**Recommendation:** Approve

**Applicant:** Peveril Securities Ltd and Sladen Estates Ltd

**Proposal:** Variation of Condition 4 (approved plans and documents), Condition 30 (highway design) and Condition 34 (employment floor space limit) of 17/02534/OUT relating to the erection of a business park of up to 60,000 sq.m (GEA) of flexible Class B1(a) office / Class B1(b) research & development floorspace (now under Use Class E); associated vehicle parking, landscaping, highways, infrastructure and earthworks (Original Application accompanied by an Environmental Statement)

PROJECT:
Lakeview Drive
Bicester
TITLE:
Indicative Parameters Plan
SCALE: 1:1250 @A1
ORIGIN DATE: 30/03/23
DRAWN: CC
CHECKED: JB
STATUS: PLANNING
PROJECT DRAWING NO: 05935 -SPA-MP-00-DR-A-9010
ARCHITECTURE | MASTERPLANNING | INTERIORS | GRAPHICS | BRANDING

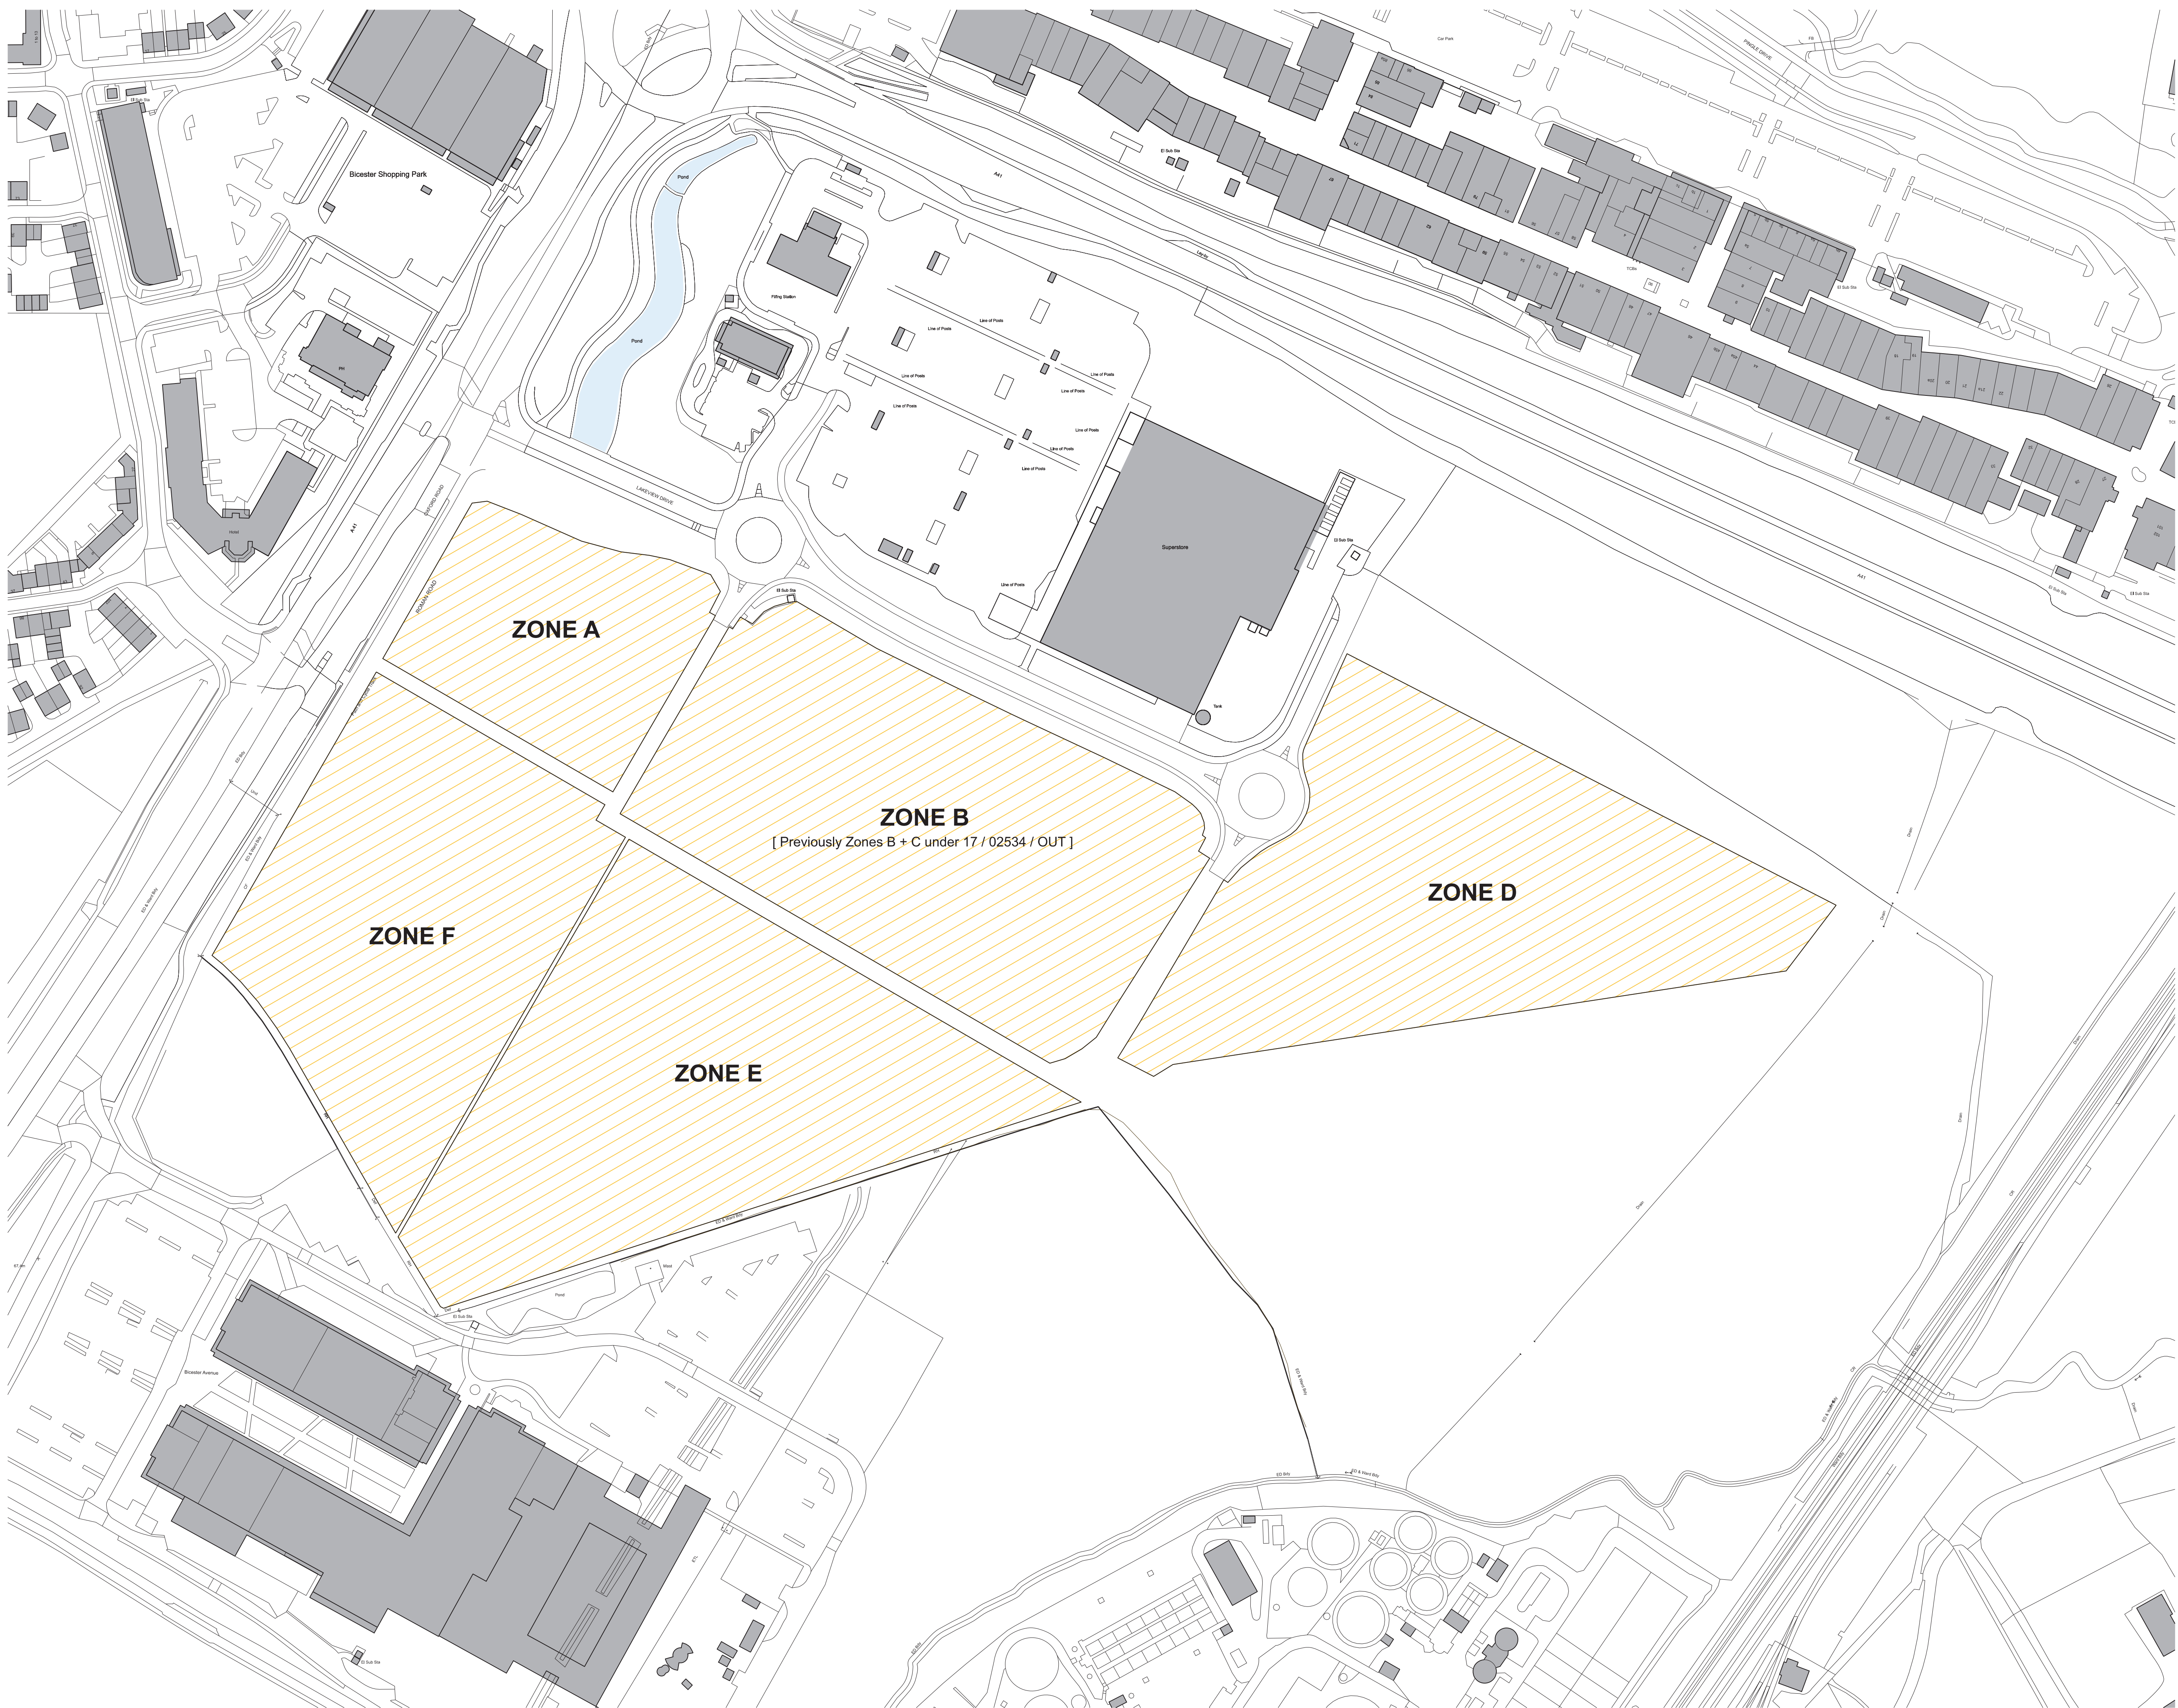
*They would like to highlight the development parameter plan submitted at outline stage included the identification of the 1% plus climate change extent (the design flood) with an indication within the outline application that this area would not be built on. The parameter plan submitted with this varied application does not include the same detail. This should not present any concerns as the flood risk assessment approved under condition 5 of the outline consent stipulates that there will be no development within the design flood extent and no land raising in flood zone 3b.*

- 8.7 The outline planning permission fixed the key principles for development on the site, including the height of the buildings in each zone. The parameter plan (1105\_P\_005 Rev. E), Table 4.1 of the Environmental Impact Assessment dated December 2017 and page 11 of the Design and Access Statement dated August 2018 which secured most of the principles were included within Condition 4 – ‘Approved Plans’.

- 8.8. The applicant now wishes to make some small material amendments to the scheme to allow for an increase in height in some of the buildings, revised design principles and improvements to the junction shared with the A41 (Oxford Road).

- 8.10. For completeness, the changes in height for each zone (as set out in Table A of the Planning Statement) would be:

<b>Maximum Building Heights</b>		
	<b>Building Heights Extant Consent</b>	<b>Building Heights Proposed</b>
<b>Zone A</b>	<b>20m</b>	<b>21m</b>
<b>Zone B (Previously Zones B &amp; C under 17/02534/OUT)</b>	<b>16m</b>	<b>21m</b>
<b>Zone D</b>	<b>16m – 20m</b>	<b>21m</b>
<b>Zone E</b>	<b>16m</b>	<b>21m</b>
<b>Zone F</b>	<b>20m</b>	<b>21m</b>
